27 March 2018

Section 4.55 (1A) Car Park Assessment – ATP Building 2, 2 Locomotive Street, Eveleigh

ptc. has been engaged by Mirvac to assess the revised car parking layout for the proposed Section 4.55 (1A) submission in relation to the development ATP Building 2 at 2 Locomotive Street, Eveleigh.

scale 1:250 @ B1 first issued 8/2/18
project code sheet no. revision
MVATP fjmt-AR-DWG-BB-B2-300L-R 02

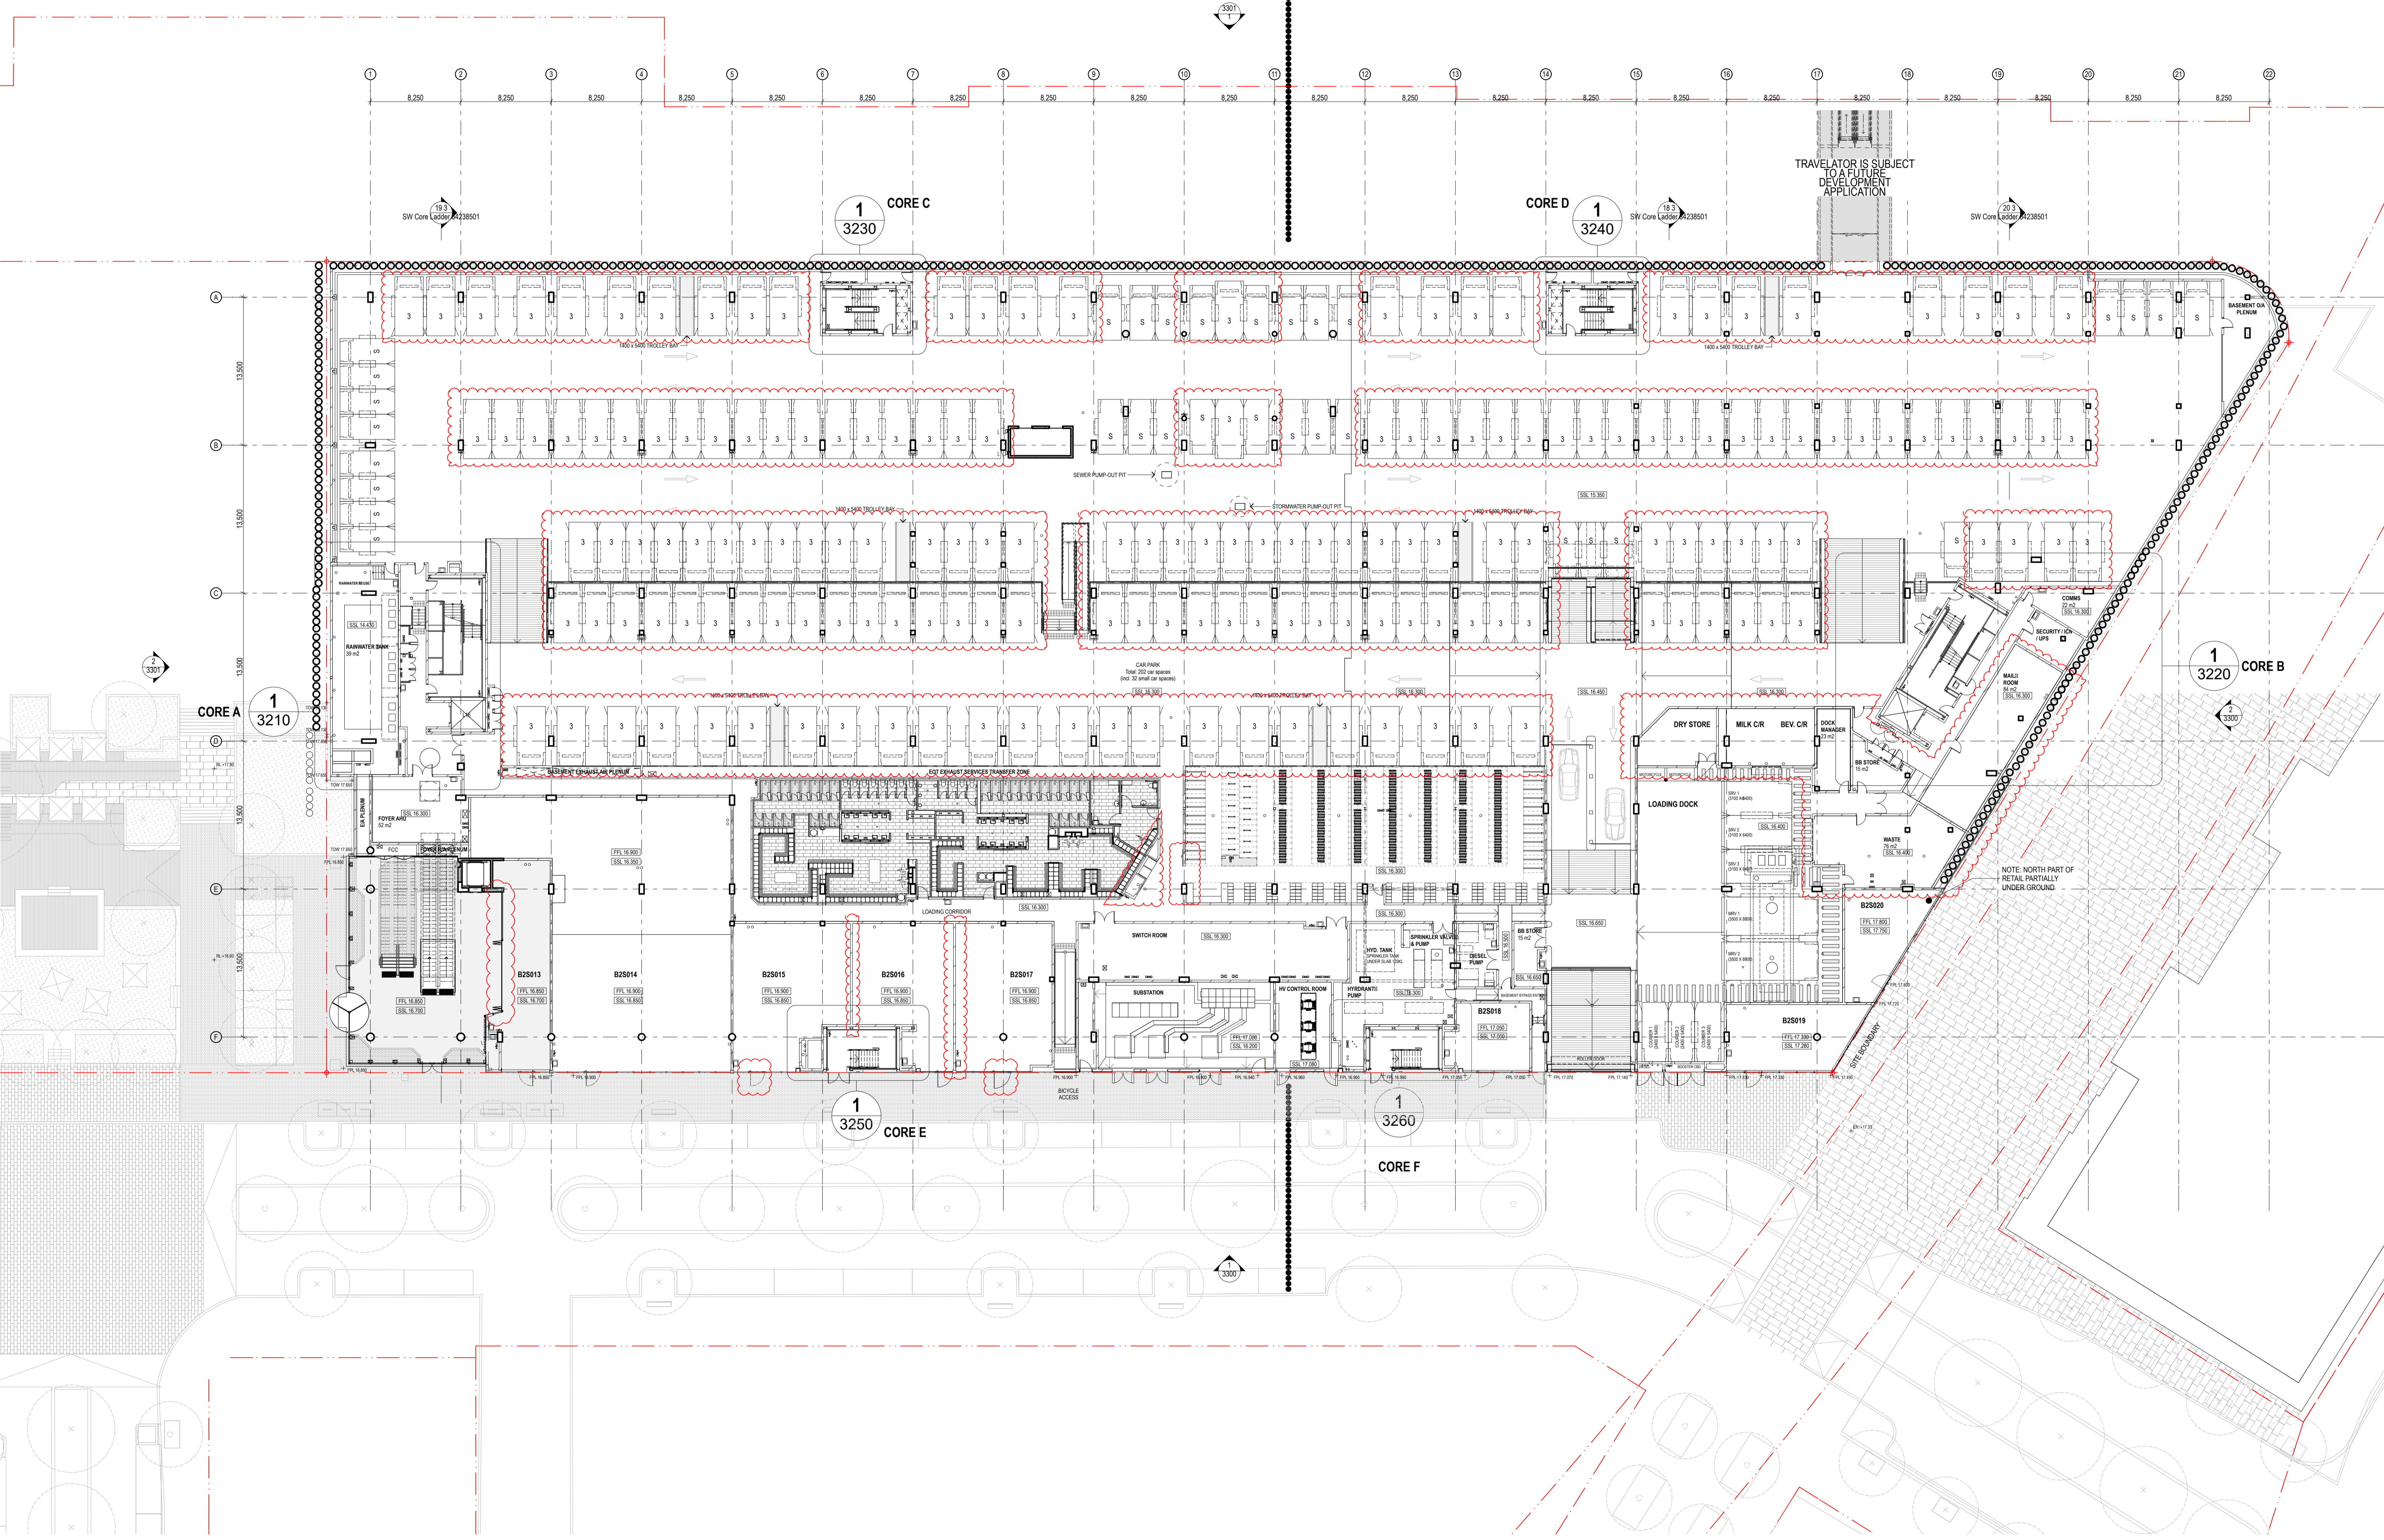
We have undertaken an assessment of the proposed amendments with reference to the provisions contained in AS2890.1. Our assessment has been undertaken with reference to the drawings prepared by fjmt + SISSONS:

Component	Requirement	Provided	Compliance	Notes
Class 3 Short-Term City and Town Centre Parking				
Space Length	5.4 m	5.4 m	✓	
Space Width	2.6 m	2.6 m	✓	
Aisle Width	5.8 m	5.8 m	✓	
General Car Park Requirements				
Aisle End-Treatment	1 m extension	1 m extension	✓	
Door Opening Area	0.3 m	0.3 m (min)	✓	
Typical Height Clearance	2.2 m	2.3 m	✓

The area of the car park, affected by the proposal, has been reviewed against the requirements of AS2890.1 (Off Street Car Parking). It was found that the changes made to the car park are compliant with the standards. In light of this, **ptc.** confirms that the conversion of the Lower Ground Level to a visitor car park complies with the relevant Australian Standards.
